4. **Project# 1007474**
10DRB-70335 MINOR - PRELIMINARY/
FINAL PLAT APPROVAL
JACKS HIGH COUNTRY INC agent(s) for JOHN J MAHONEY AND CAROLINE BENSON request(s) the above action(s) for all or a portion of Lot(s) A-3-A-1, **DAVID MACIAL**, and Tract(s) A-1-A, **FLORAL MEADOWS** , zoned R-2, located on MONTOYA RD NW BETWEEN FLORAL RD NW AND SARITA NW containing approximately 1.1716 acre(s). (H-12) **THE PRELIMINARY/FINAL PLAT WAS APPROVED WITH FINAL SIGN OFF DELEGATED TO TRANSPORTATION FOR COPY OF 1977 EASEMENT AND PLANNING FOR AGIS DXF.**

DRB Comments

PROJECT # 1007474

RE: Tracts A_3-A & A-1, Lands of David Macial & Floral Meadows

PLAT OF  
**TRACT A-3-A, LAND OF DAVID MACIEL**  
 and  
**TRACT A-1, FLORAL MEADOWS**  
 CITY OF ALBUQUERQUE  
 BERNALILLO COUNTY, NEW MEXICO  
 JULY 2008 SHEET 2 OF 2

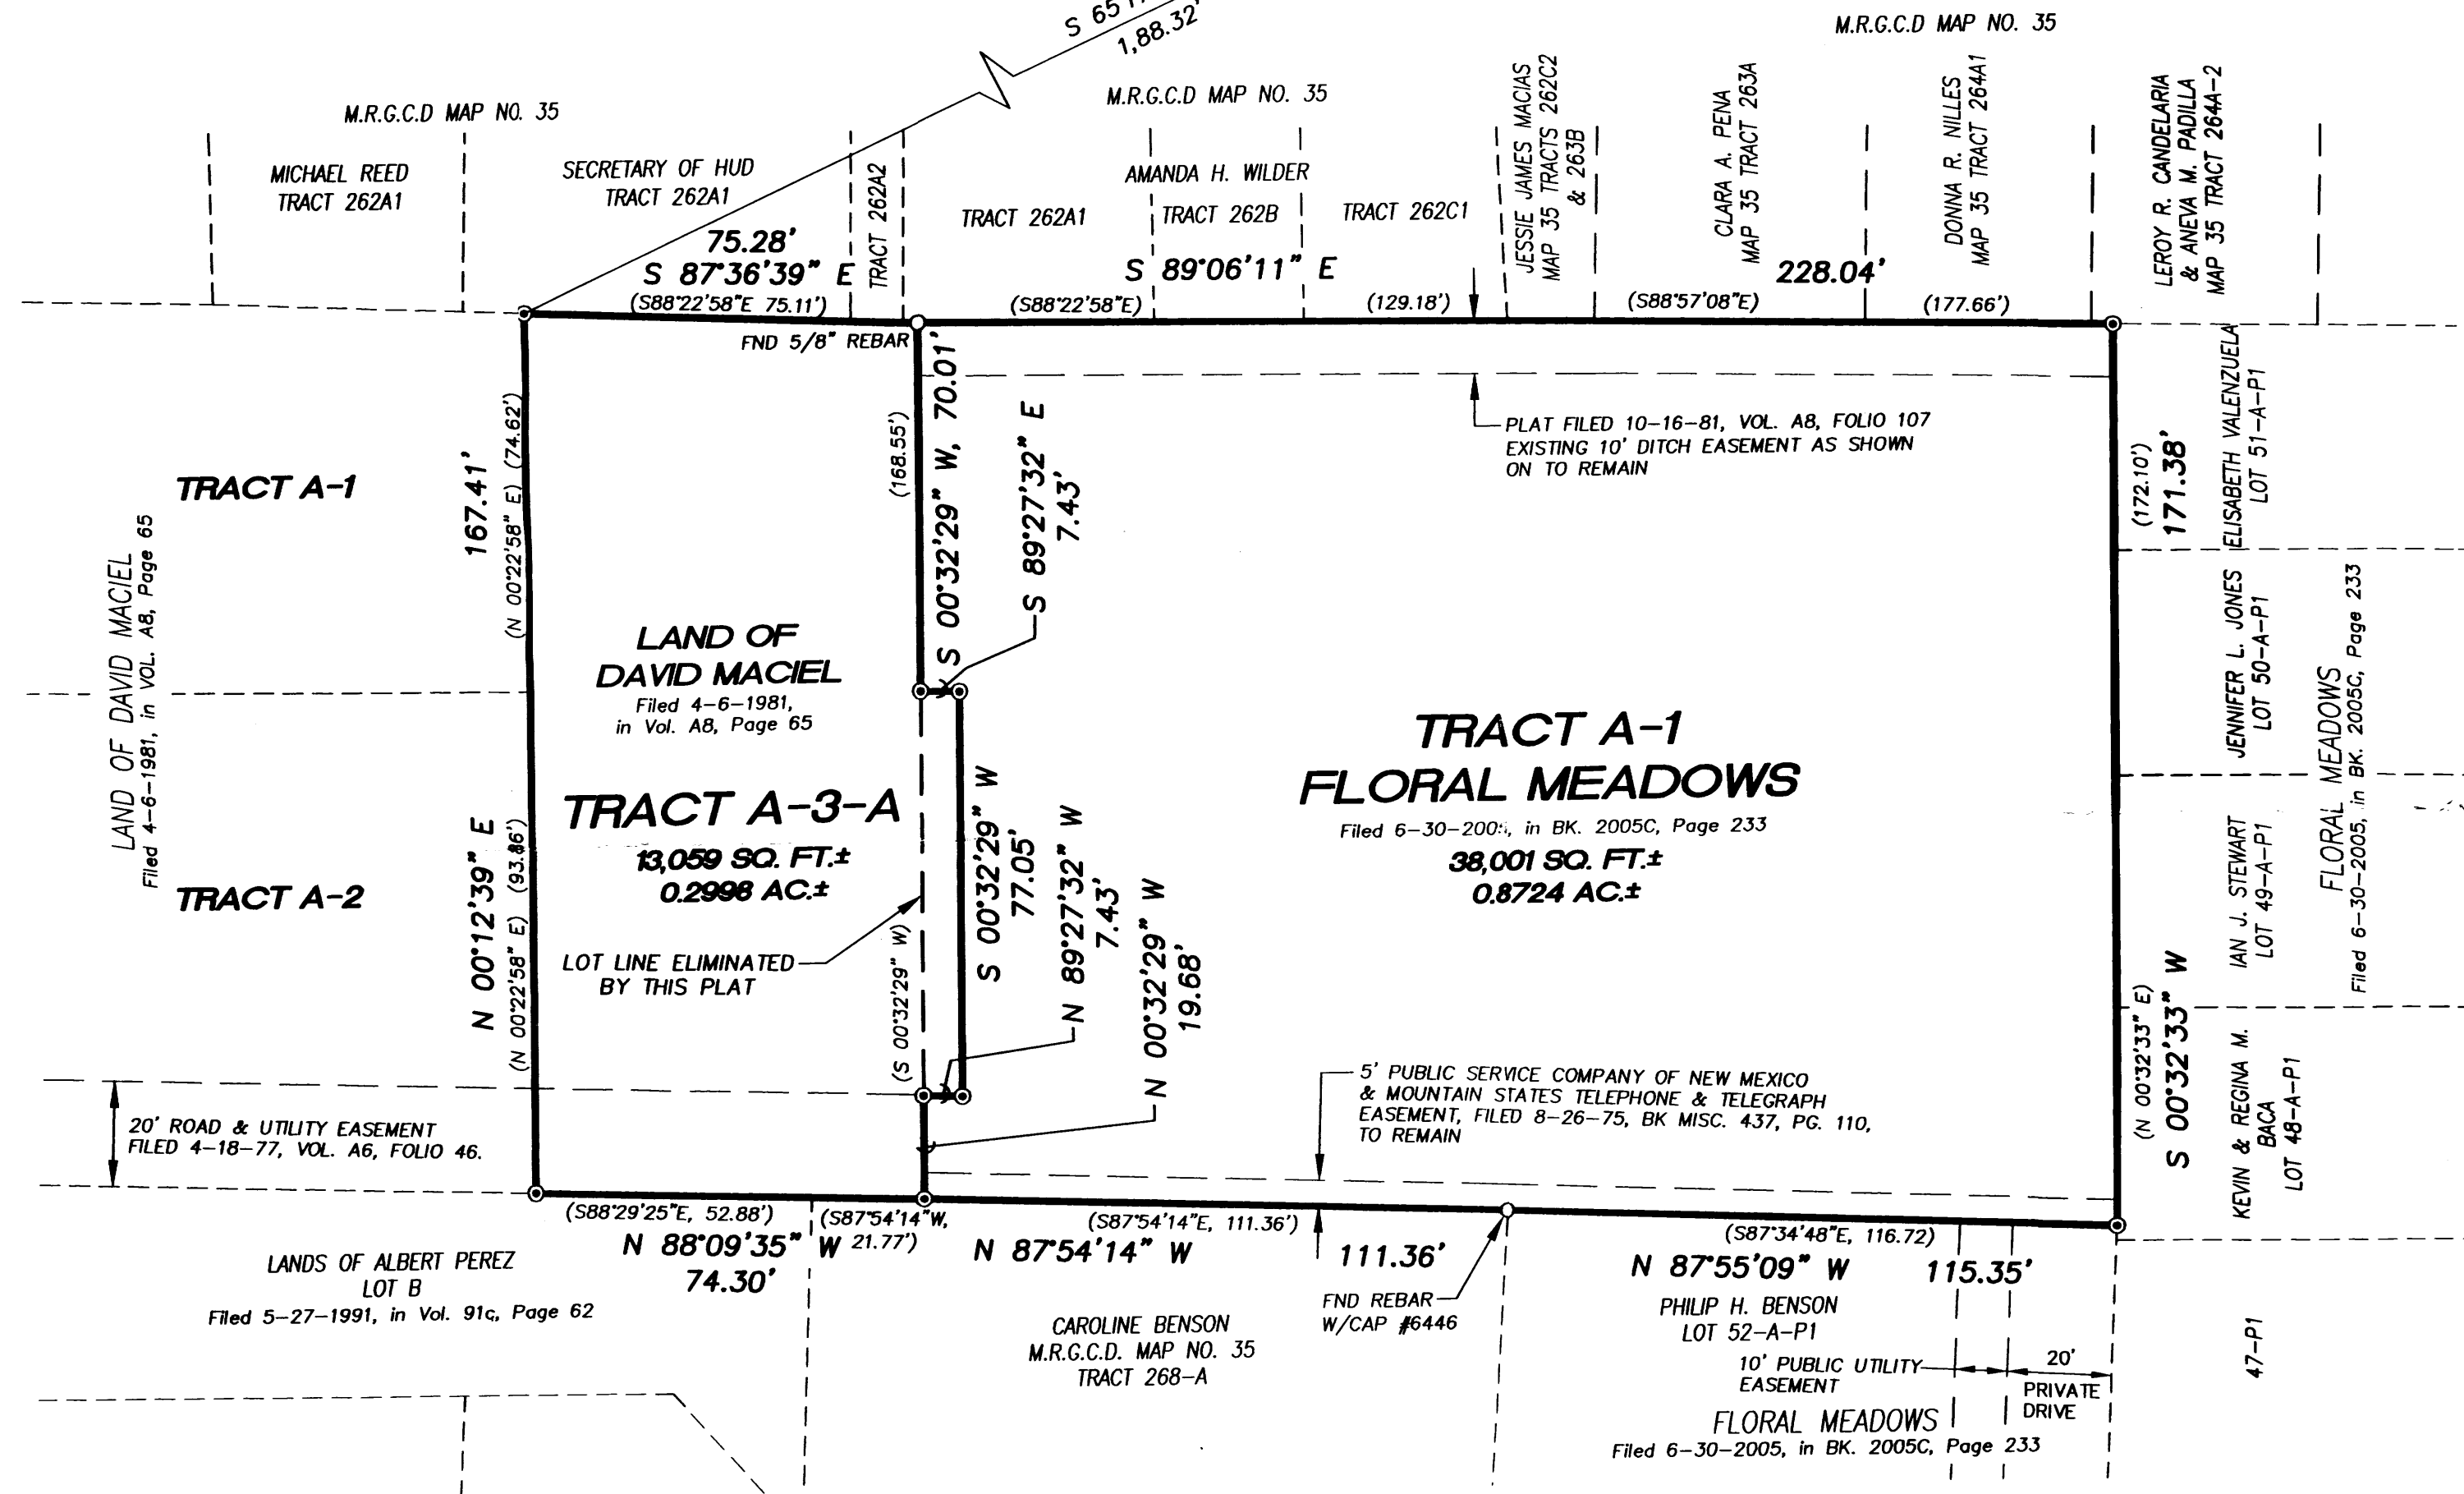
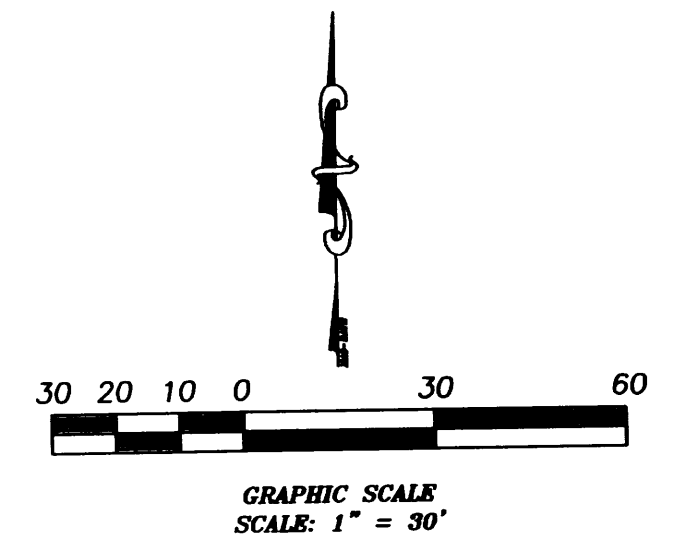
A Solar Note will be needed on the plat (consistent with Section 14-14-4-7 of the Subdivision Ordinance) which is specific to this type of request, i.e. use the words "THIS PLAT" (rather than the words "REQUESTED FINAL ACTION") at the beginning of the note, and do not use the words "OR SITE DEVELOPMENT PLAN FOR SUBDIVISION" at the end of the note.
